**Re: Warehouse for Commercial Enterprises, 8309 Washington Pl. NE, Grading  
and Drainage Plan**

**Re: Warehouse for Commercial Enterprises, 8309 Washington Pl. NE, Grading  
and Drainage Plan**

**Engineer's Stamp dated 11-19-03 (C17/D1E2)**

SHEET NO.
C.I.1

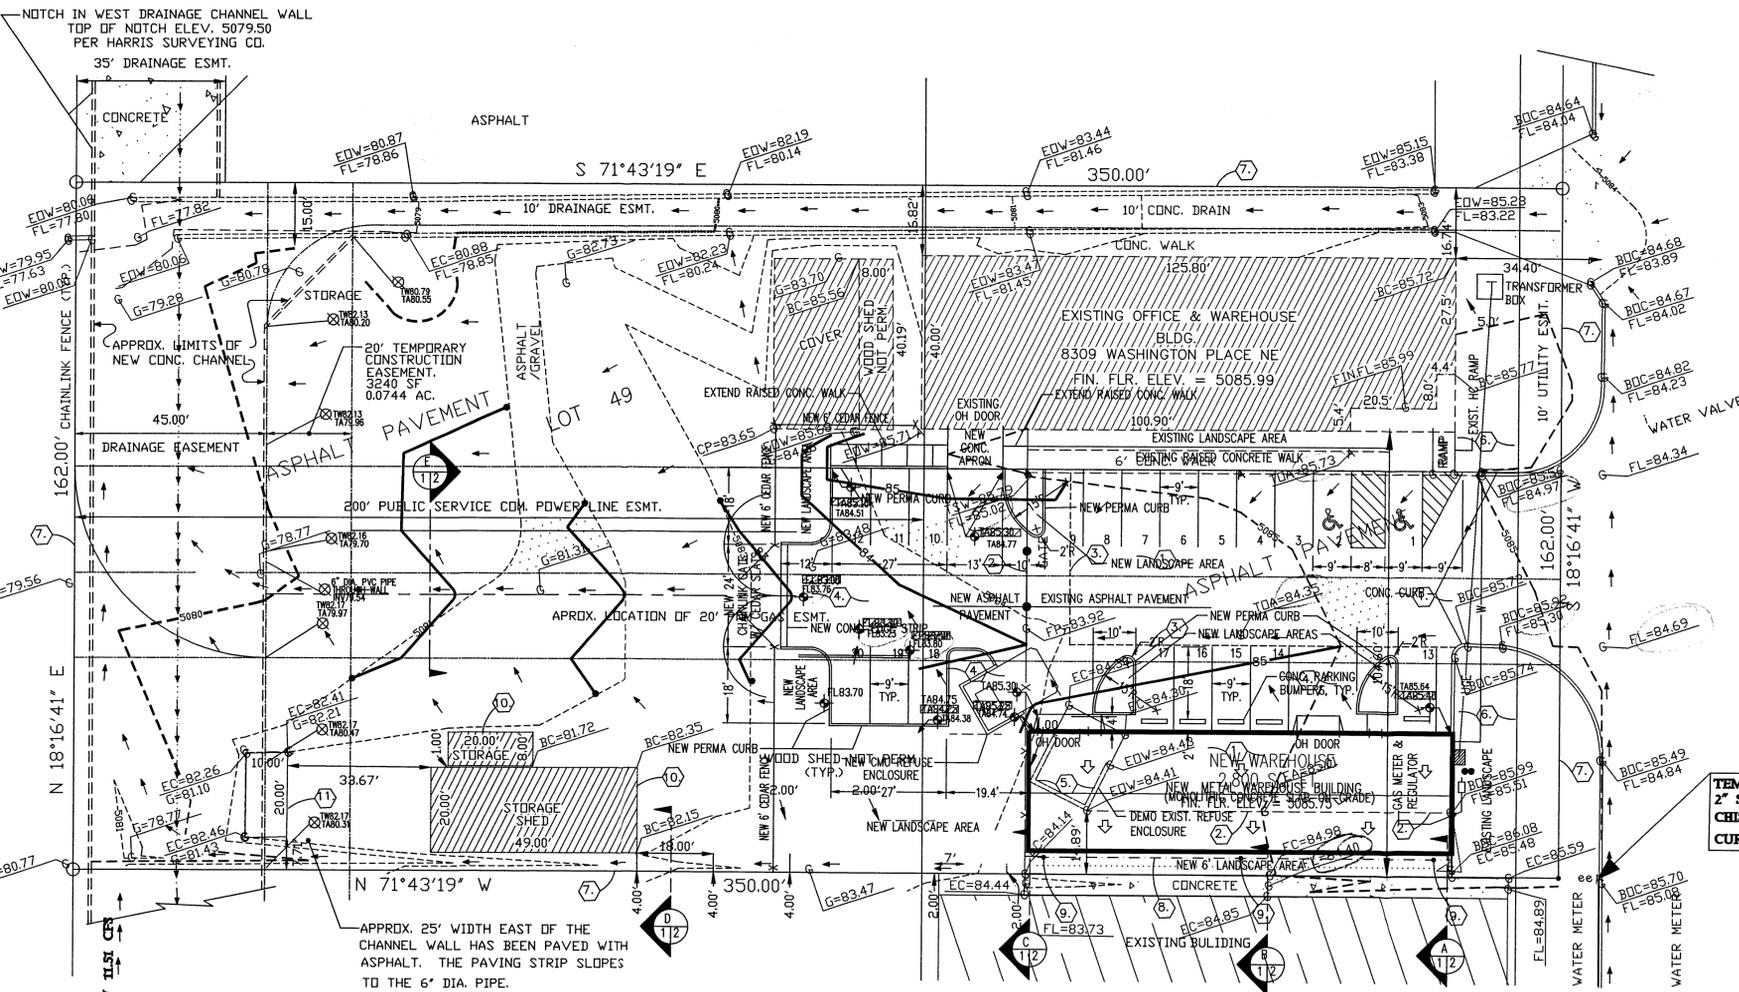
1. Please define both exiting and entering offsite flow.
2. Show the limits of all easements, including construction easements.
3. The plan should show the removal of temporary structures within the  
easements. No pavement should be placed in these areas either.
